CITY OF ALBUQUERQUE

**Re: Legends at High Desert-Emergency Overflow Supplemental Drainage
Calculations
Engineer's Stamp Date 12-09-14 (E23D003B)**

Based upon the information provided in your submittal received 12-10-14, the above referenced report is approved for the emergency overflow and for Building Permit on Lot 28 with the following condition:

IN-LINE DRAIN WITH DOMED GRATE

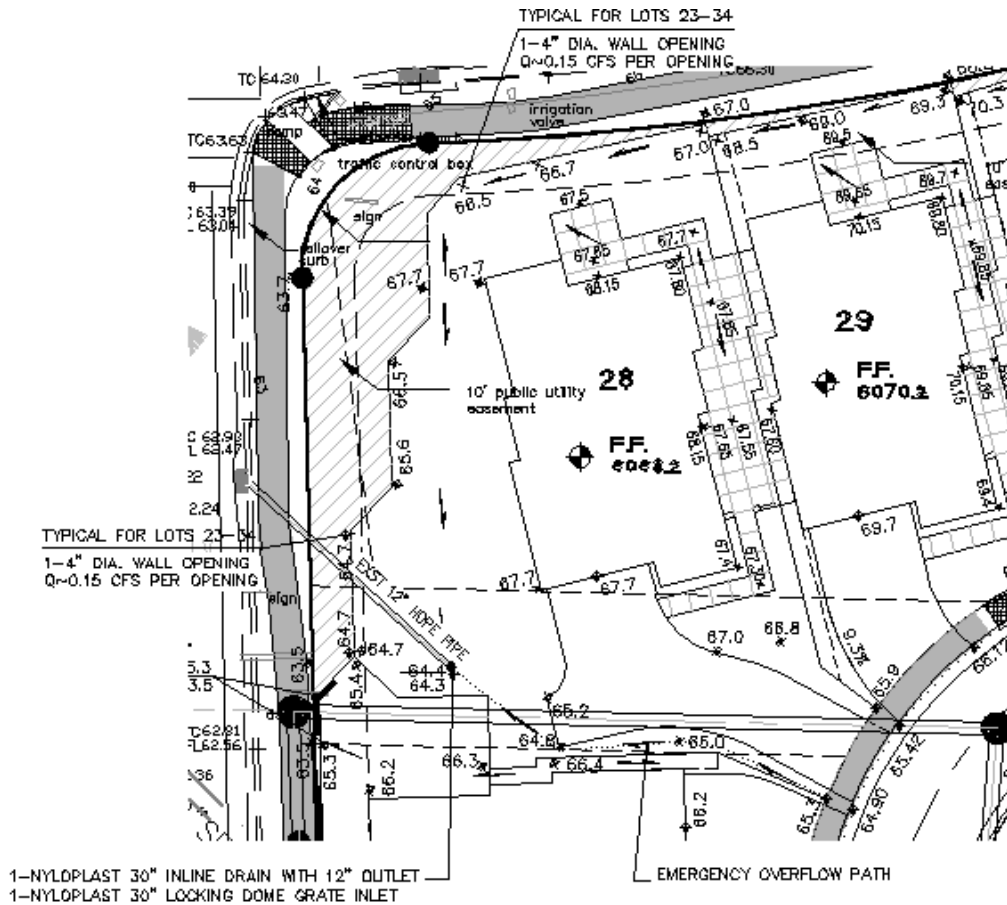
Construction details for the domed grate inlet are to be included in the Building Permit set. An engineer's certification of the site and the inlet is required to obtain a Certificate of Occupancy.
